**Re: BIA SWRO Demolition– 1833 8th St NW
Erosion and Sediment Control Plan
Engineer's Stamp Date – 10/18/2023 (H14EXXX)**

Based upon the information provided in your submittal received 11/7/2023, the above referenced ESC Plan can't be approved until the following comments have been addressed.

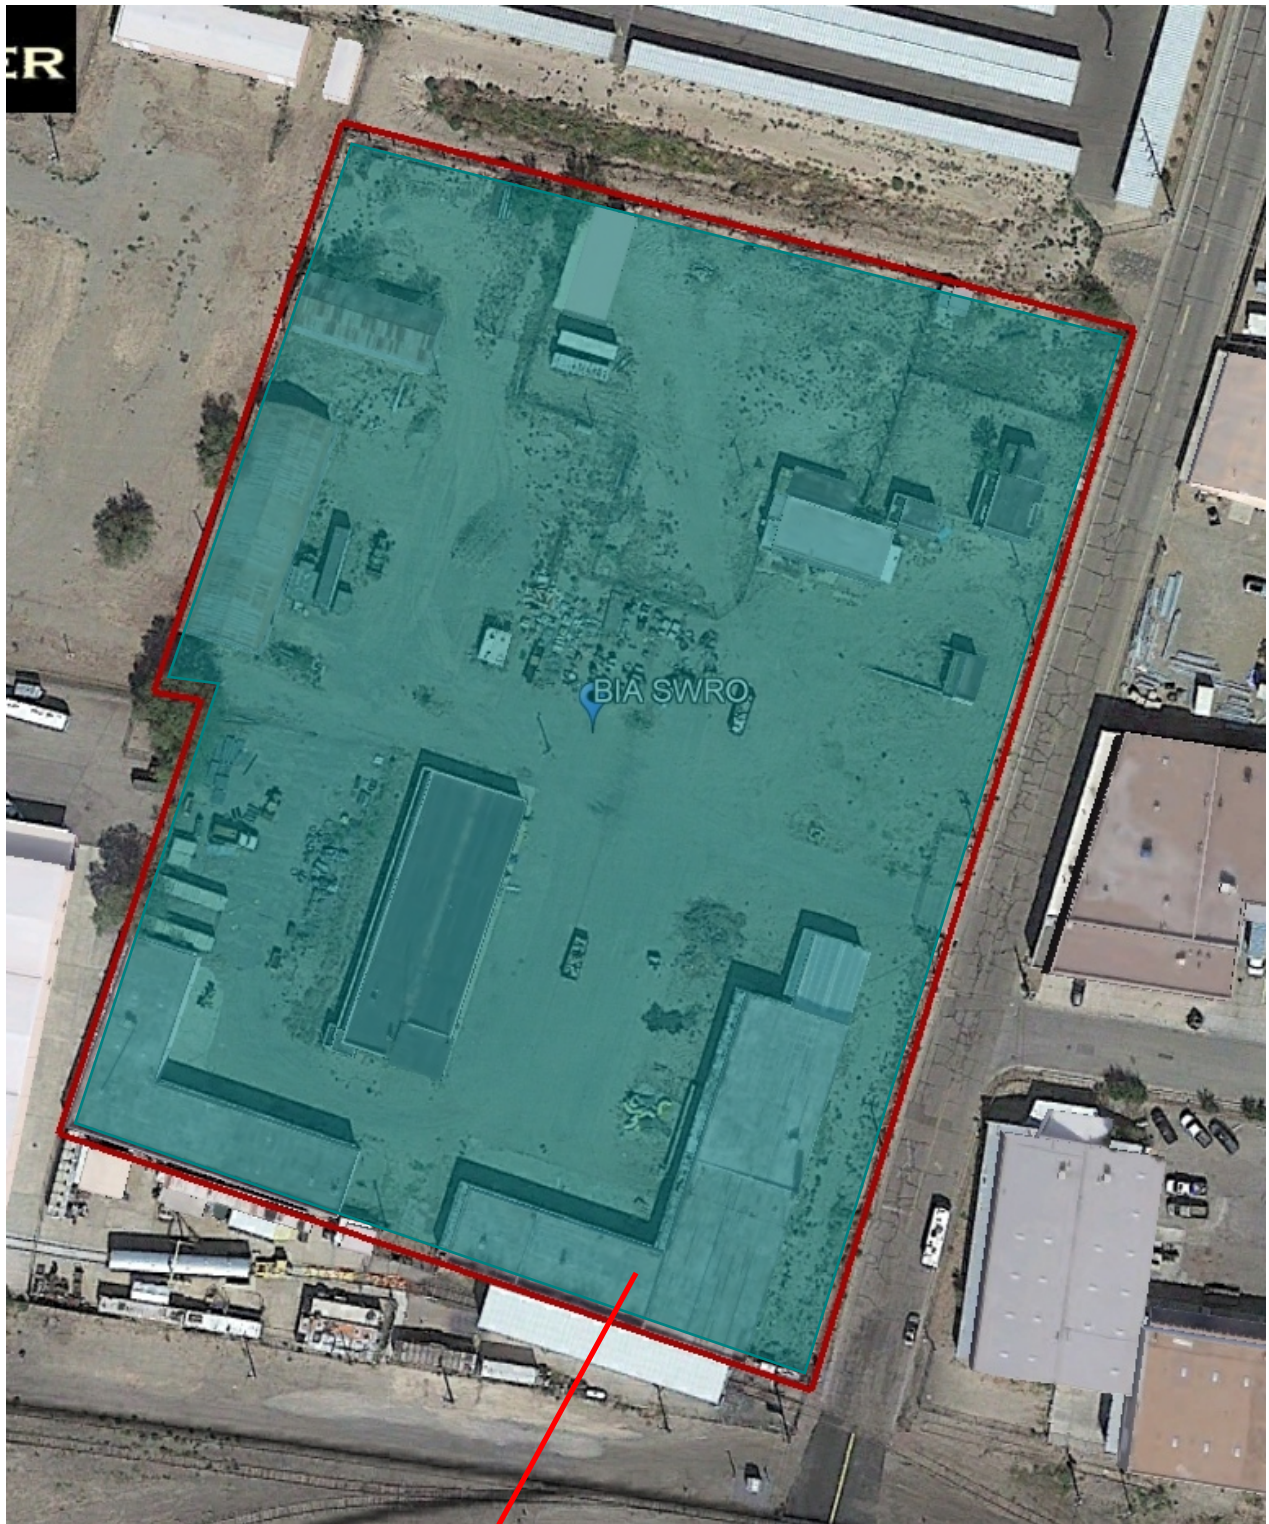
1. The total disturbance for the demolition is greater than 10,000 sq. ft., so a G&D plan is required to be approved by Hydrology. The existing and proposed grades must be shown on the ESC Plan, and they must agree with the Grading Plan approved by Hydrology (CGP7.2.4.b.ii).

2. The limits of disturbance on the ESC Plan do not match with the property lines on County Records. The building on the southwest corner appears to be on the neighboring property. Property lines need to be shown on the ESC Plan, not just the limits of disturbance. If disturbance occurs on the neighboring property, the owner of that property must also file and submit a NOI. It is possible that property lines have changed recently, if so, please provide documentation showing the new boundaries.
